From: Paul Cann <Paul.Cann@arun.gov.uk>
Sent: 06 February 2020 15:41
To: Michael Eastham <Michael.Eastham@arun.gov.uk>
Cc: Sarah Burrow <Sarah.Burrow@arun.gov.uk>
Subject: RE: BN/85/19/DOC - The Lillies

Comments on proposals;

Please find attached 2 revised drawings for BN/85/19/DOC at the Lillies, Yapton Road, Barnham.

REV	DESCRIPTION	DRN	CHD	DATE
☒ PRELIMINARY	☐ INFORMATION	☐ TENDER		
☐ CONSTRUCTION	☐ AS BUILT			
SCALE	1:200 @ A1	DATE	JULY 2019	
DRAWN	WFN	CHK	CLS	
DRAWING NO.	17748-BARN-5-600	REV	-	
TITLE	YAPTON ROAD BARNHAM			
DETAILS	ENGINEERING LAYOUT SHEET 1

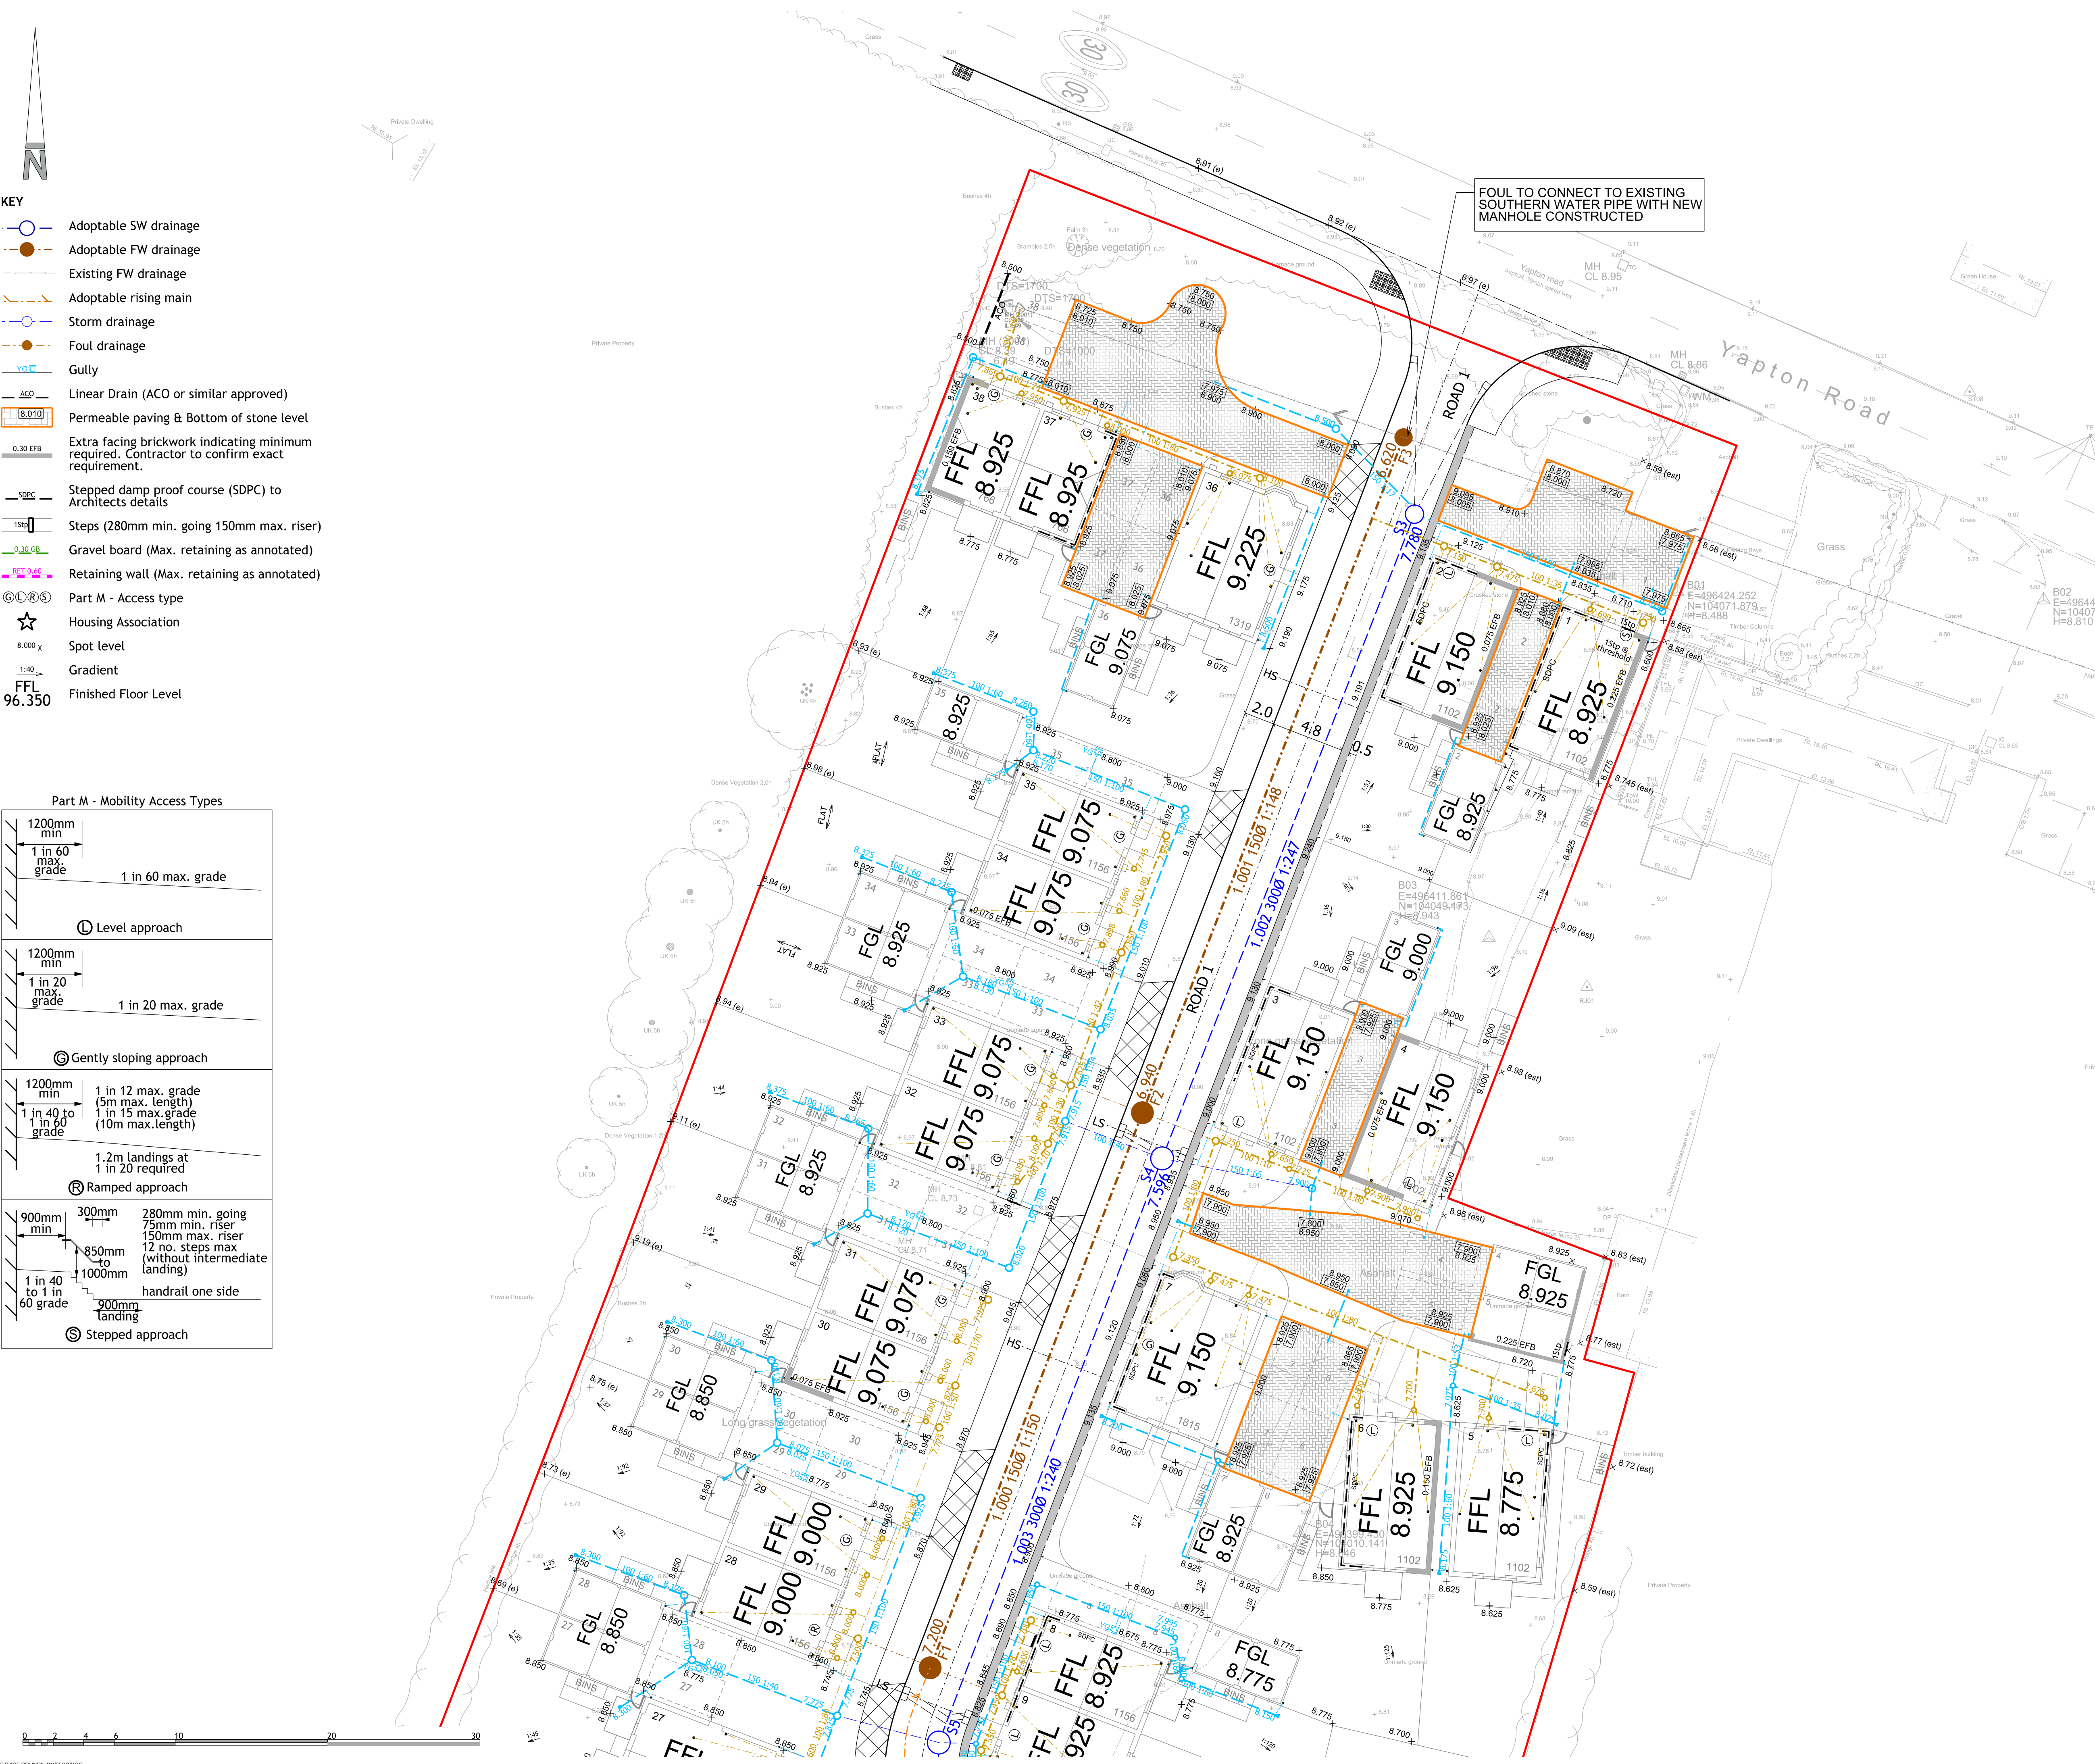
1. I note that the surface water sewers are being offered for adoption to Southern Water. As a result, they will also need to agree the proposals.
2. The top of bank of the proposed pond needs to be kept at least 3 metres away from the top of the bank of the ditch to allow maintenance access and comply with our land drainage byelaws.

3. The path (assumed to be unfenced) for plot 17 appears to be within 3m of the top of the bank of the ditch. Since this encroaches into 3m working width for machinery required for ditch clearance, please confirm that the path will be designed to accept loadings from suitable machinery and that it will not be fenced off. Add notes to drawing.

4. The ground slope adjacent to plot 17 will prevent safe access for maintenance – please rectify.
5. Southern Water requires the pond to be located at least 5m away from the proposed pumping station. It is unclear as to whether this has been achieved.

7. All outlets from the permeable paving to be discharged via a diffuser unit. Specify pipe outlet invert levels and ensure all pipes have a diameter.
8. Manhole adjacent plot 38 – invert level missing.

9. Permeable pavement between plot 36 and 37 – outlet arrangement is not clear.
10. Link pipes between permeable pavements – specify diffuser units at each end, pipe inverts and diameters.

13. Has the level of the existing rising main been established to confirm that there is no clash with pipe length S5 to S6?
14. Add note 'All pipes to be connected at soffit to soffit level'.

18. Specify pipe materials.
19. Gullies near S5 should connect directly into S5.
20. Manhole downstream of permeable paving adjacent plot 12 – specify invert level.

29. Ditch headwall – add note 'No part of structure to encroach into the ditch profile'.
30. Specify manhole S8A as a catchpit and provide construction detail.

31. Headwalls – add note 'To be bedded as per manufacturers recommendations'.
32. Provide manufacturers technical data sheet for the hydrobrake.
33. Specify invert level on drawing where discharging to the ditch. We need to achieve as much freeboard as possible between ditch bed and pipe invert – at present this is insufficient. Please investigate lifting the pipe invert and/or regrading the ditch.

TYPICAL CROSS SECTION ACROSS PERMEABLE BLOCK PAVED DRIVES INCORPORATING IMPERMEABLE BLOCK PAVED SERVICE CORRIDOR

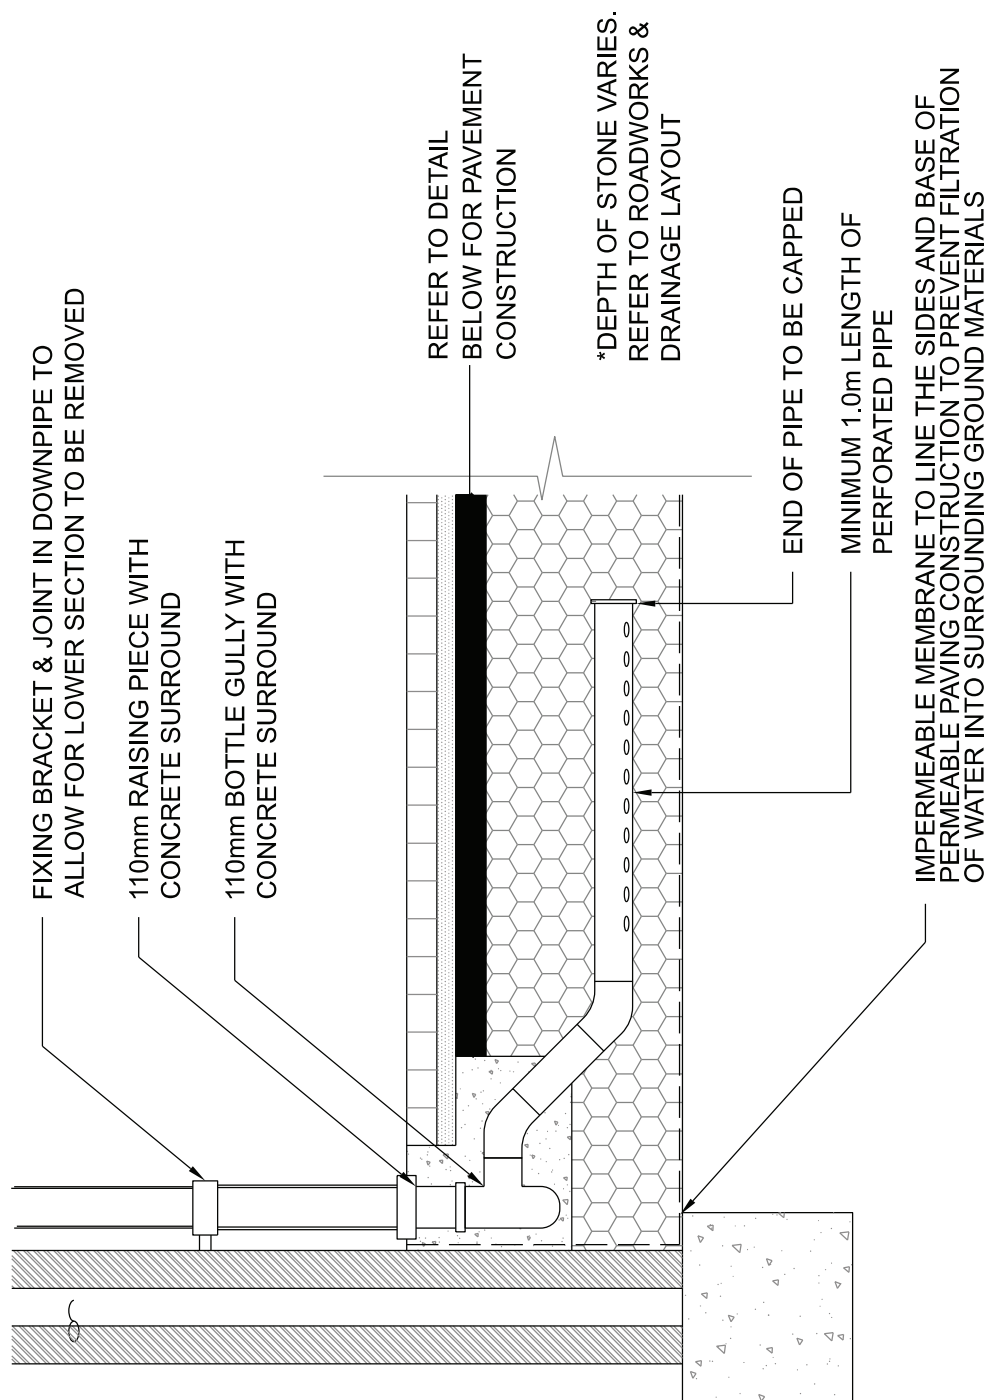
11. Make sure all RWP's are shown clearly ie. thicken lines.
12. Where the existing public foul sewer gravity sewer and rising main passes beneath the permeable pavements, are you proposing the service corridor construction arrangement – If so, detail how water can flow between the separate sub bases.

DETAILS	TYPICAL HEADWALL DETAILS
---------	--------------------------

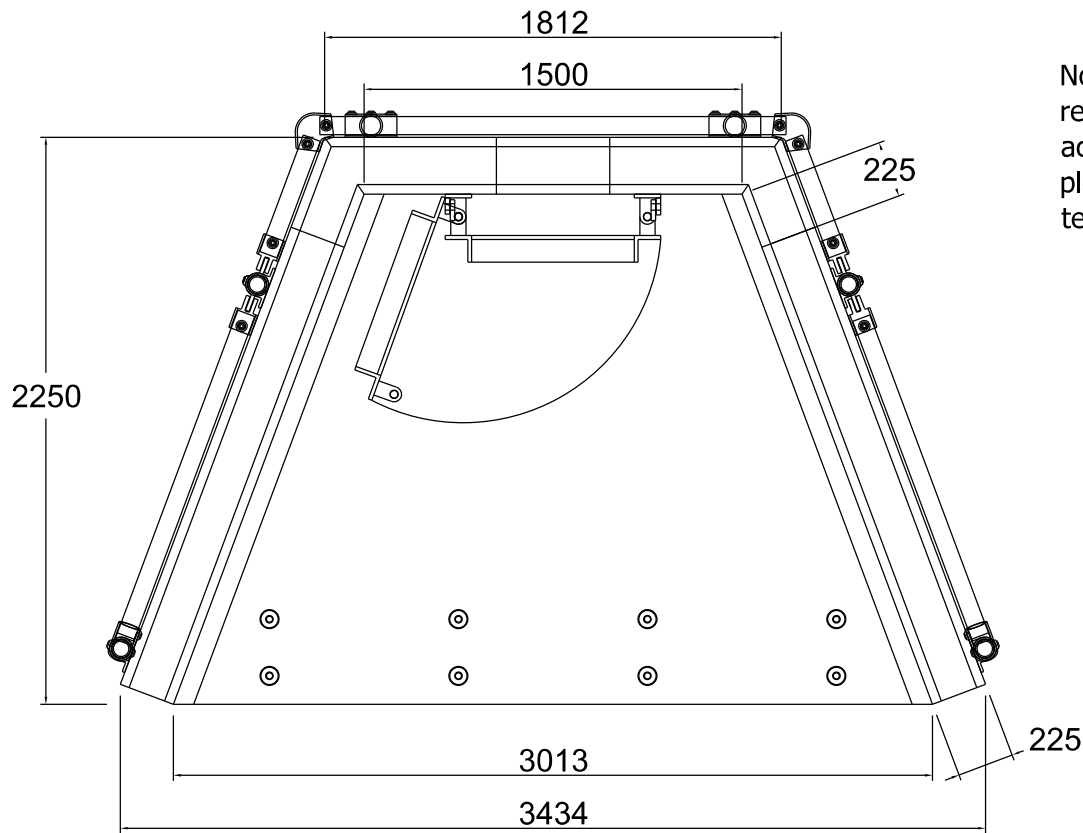
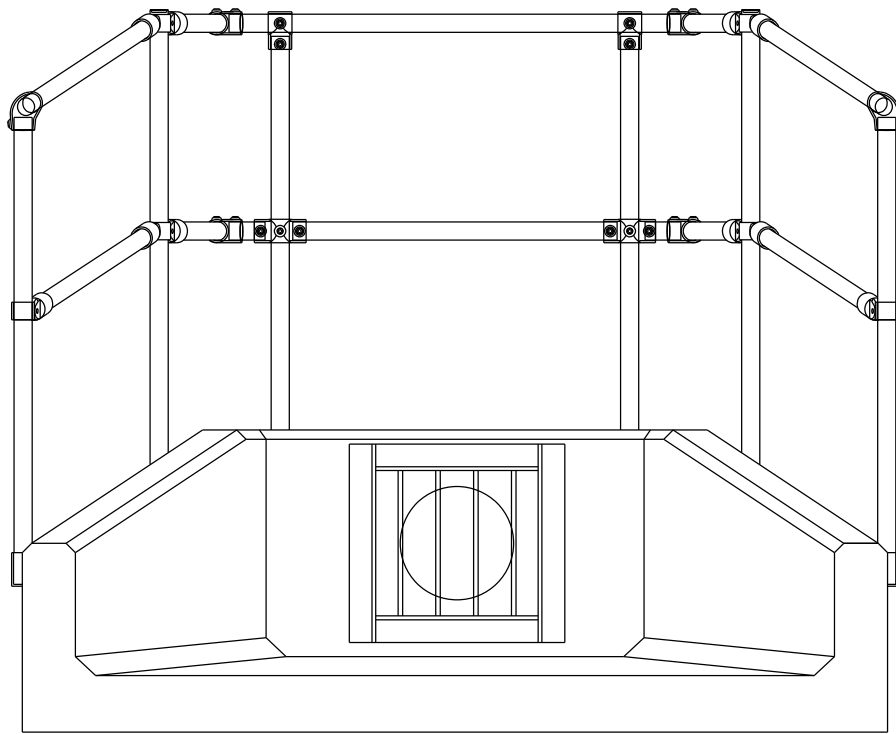
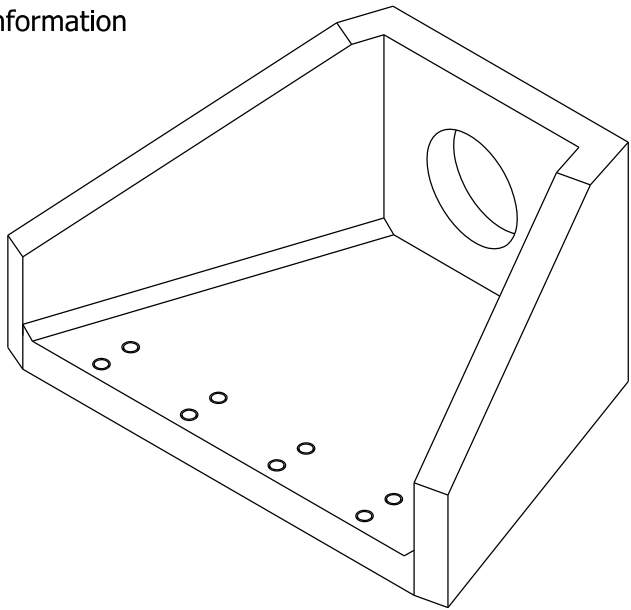
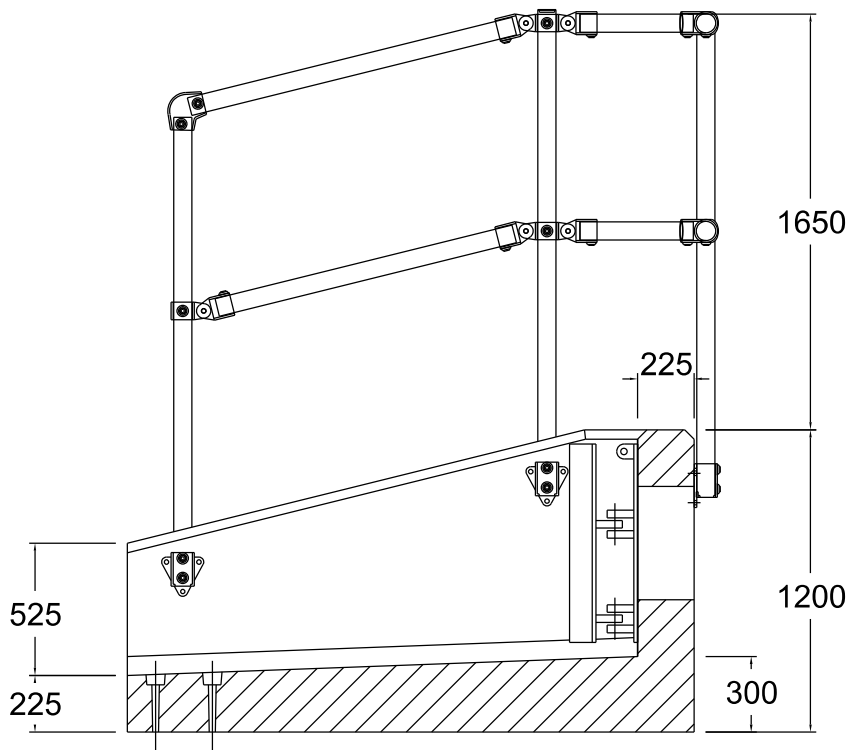
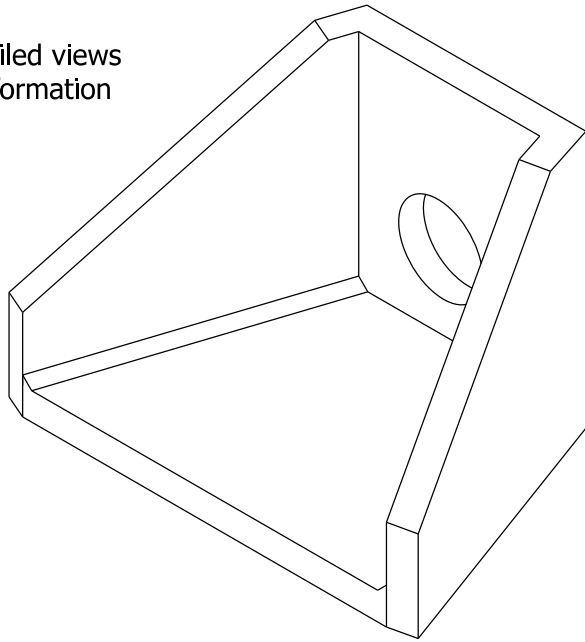
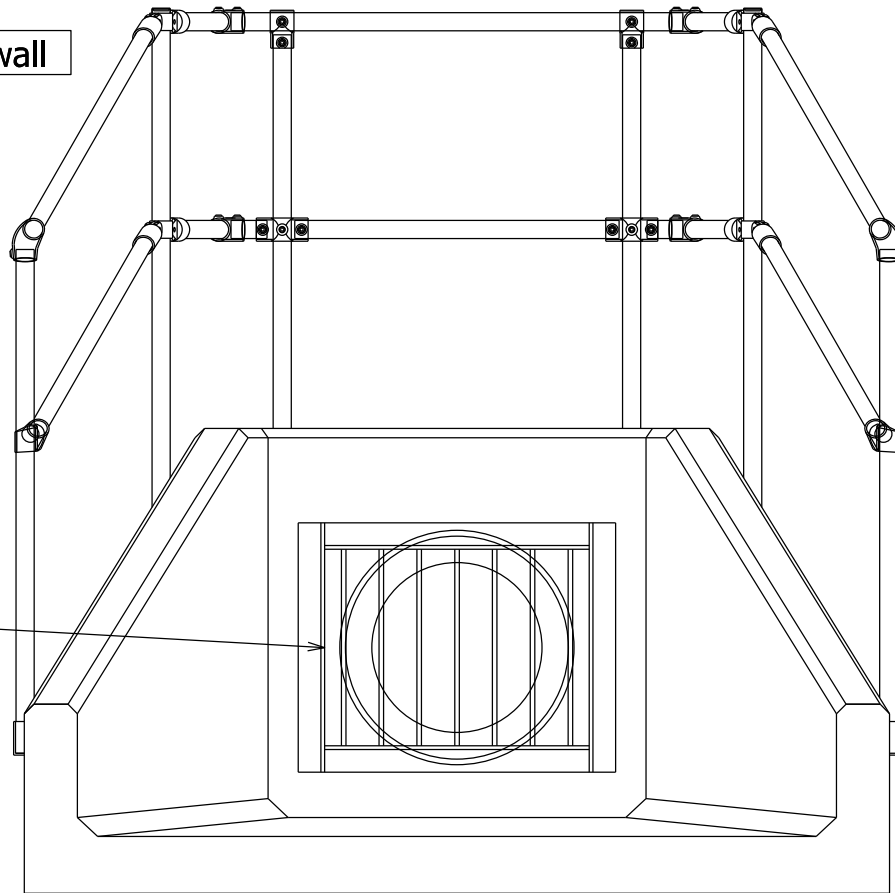
27. Headwall SFA10A incorrectly specified for the pond headwall – this should be SFA10C and SFA10A specified for the discharge to the ditch.
28. Pond headwall – specify a 'cranked' grille to suite a 450mm pipe. Banks in vicinity of headwall to be profiled to suit wing walls – add note.
